Please upload to FP/228/21/T as Planning Correspondence – Parish Council Comments additional information

FP/228/21/T REF: OWPC41764

I am pleased to show below the report and images that accompanied the comments submitted by Felpham Parish Council's Tree Warden, Jon Bray:

11A OUTERWYKE AVE

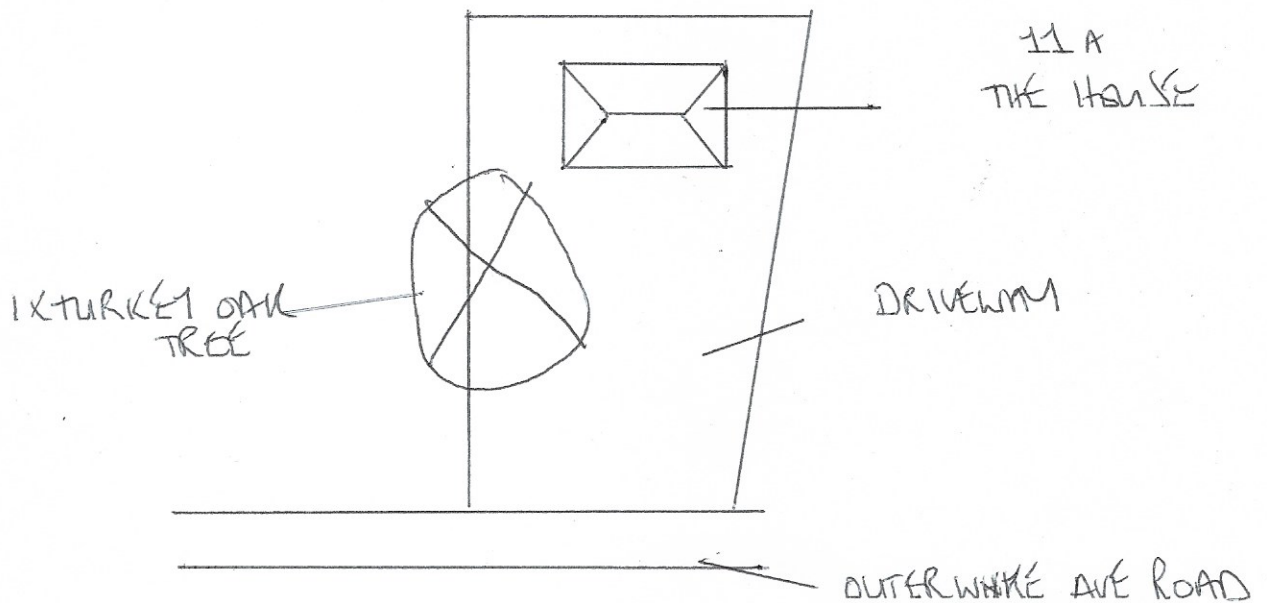
11A Outerwyke Avenue: To keep turkey oak in a managed state, (based on its location and proximity to residential dwellings), the requested reduction of 2m to all limbs appears to be reasonable. However, on closer inspection there appears to be honey fungus fruiting bodies (destructive fungus which spreads underground killing roots) at the base of the tree and in a large cavity on the main trunk. I'd suggest the property owner obtains an arboricultural survey and resubmits an application based on the findings. Removal of tree is probable.
